**Land north of Sefter Road and 80 Rose Green Road, Pagham
S96A application seeking minor changes canopies at plots 206 and 222**

Taylor Wimpey Southern Counties submit an application for a non-material amendment ('NMA') to the reserved matters approval (ref. P/49/21/RES) at land north of Sefter Road and 80 Rose Green Road. This application is submitted under Section 96A of the Town and Country Planning Act 1990 and seeks to change canopies at plot 206 and plot 222.

GRP Trussed Apex Door Canopy

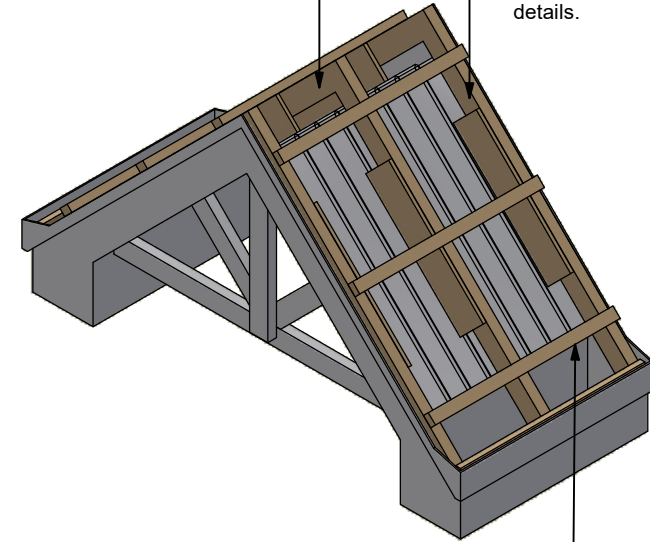
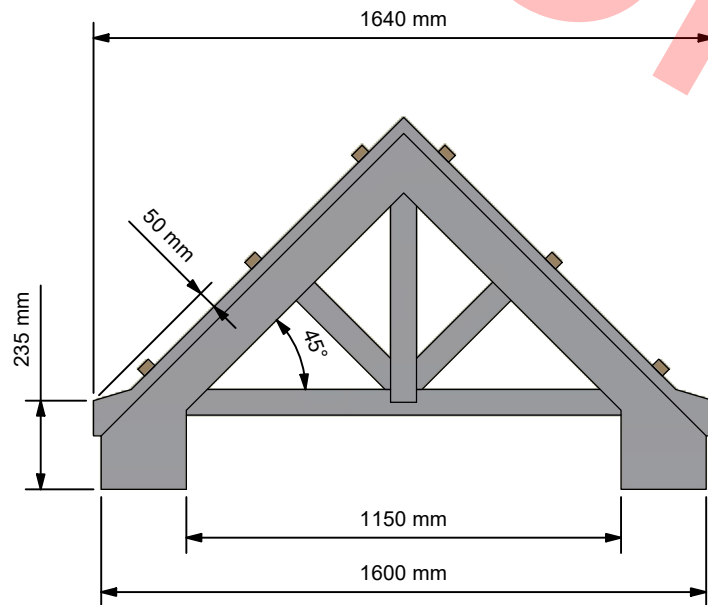
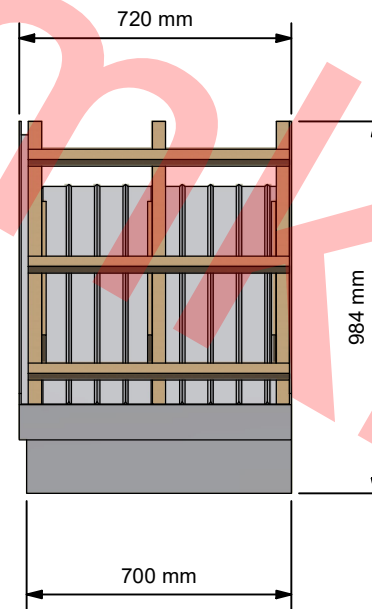
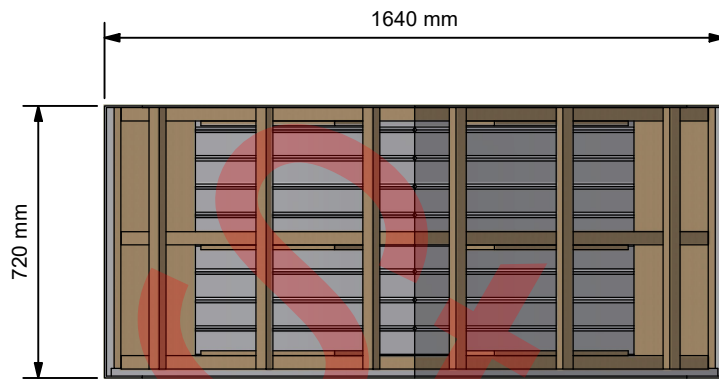
This NMA application proposes changing the canopies to plots 93 and 94.

The approved scheme shows flat top style canopies on plots 93 and 94. We are now proposing to change these to apex style canopies.
